**KIRKLEES METROPOLITAN COUNCIL  
INVESTMENT & REGENERATION SERVICE**

**DELEGATED DECISION TO DETERMINE PLANNING APPLICATIONS**

Reference No:	<b>2023/62/93162/W</b>
Site Address:	57-59, Cliff Road, Holmfirth, HD9 1UY
Description:	Erection of extensions and alterations to one dwelling to form 2 dwellings, demolition of existing external store, widen parking bay, improve external steps and access, external and internal alterations (Listed Building)
Recommending Officer:	Lucy Taylor

## **Officer Report.**

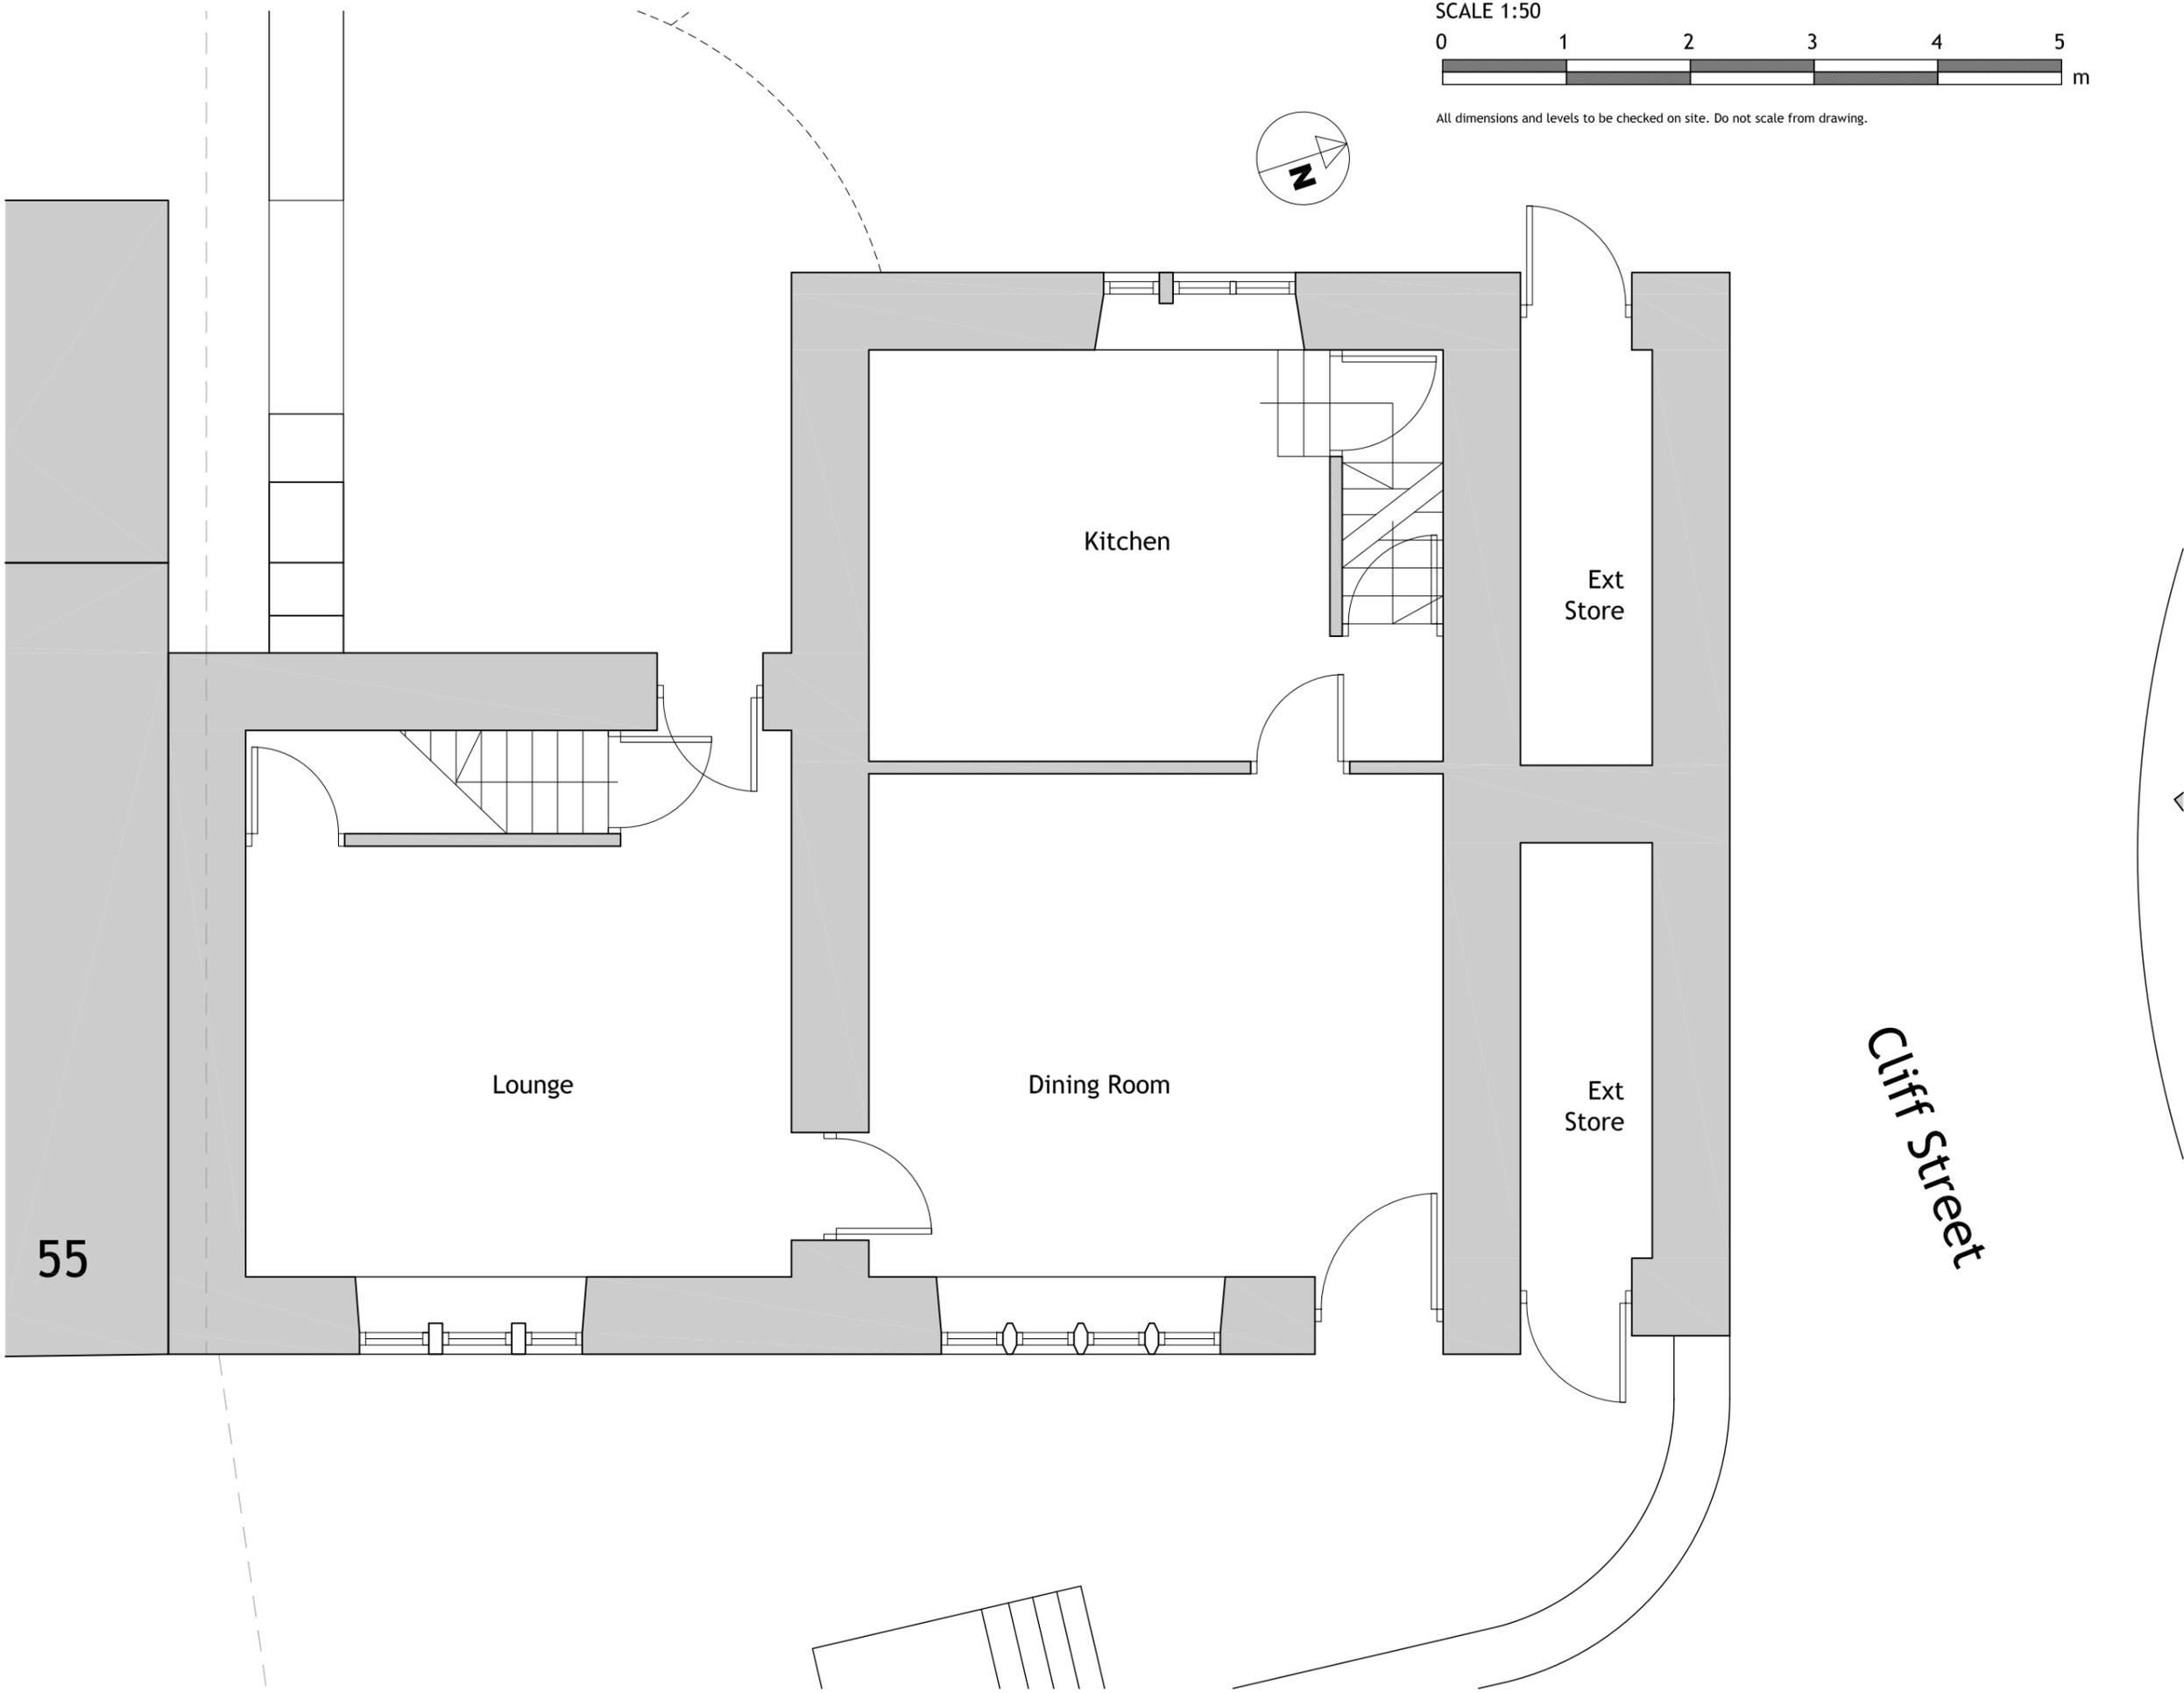
Two off-street parking spaces are proposed for No 59. However, the size of the space provided is too small for two vehicles to access safely.

Without further information, the space will only provide off street parking for one vehicle.

The Kirklees Highway Design Guide states that 3 off street parking spaces would be required for a four bedroomed dwelling.

North West (Rear) Elevation

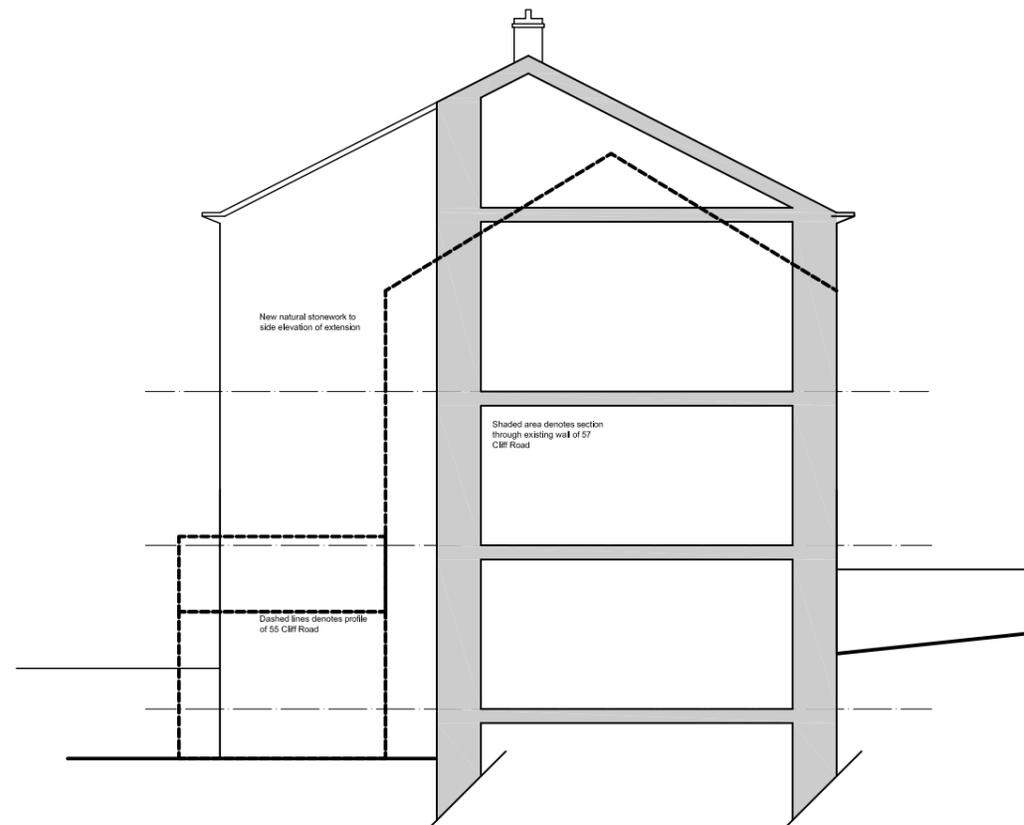
With regards to the erection of the proposed rear extension, it is considered that the loss of the existing external wall which forms a part of this development, would result in harm to the building, as it is considered integral to its understanding. Furthermore, the two-storey rear extension itself is not considered to be subservient in size / scale and while consent was previously granted at the site for an extension, this was only a modest single storey addition, which was set back from the elevation and incorporated the extant historic section of external wall. The use of matching materials would not outweigh this harm.

To conclude, whilst it is accepted that permission has previously been granted for a rear extension at the site, this was of a modest single storey size / scale and was set back from the elevation and incorporated the extent historic section of external wall. This proposal would see an extension which would compromise the historic fabric of the building, adding a piecemeal addition to the rear elevation, which would appear disjunct in its relationship to the existing built form of the host dwelling and adjoining neighbouring dwelling. This would cause further consequential harm to the wider visual amenity of the area.
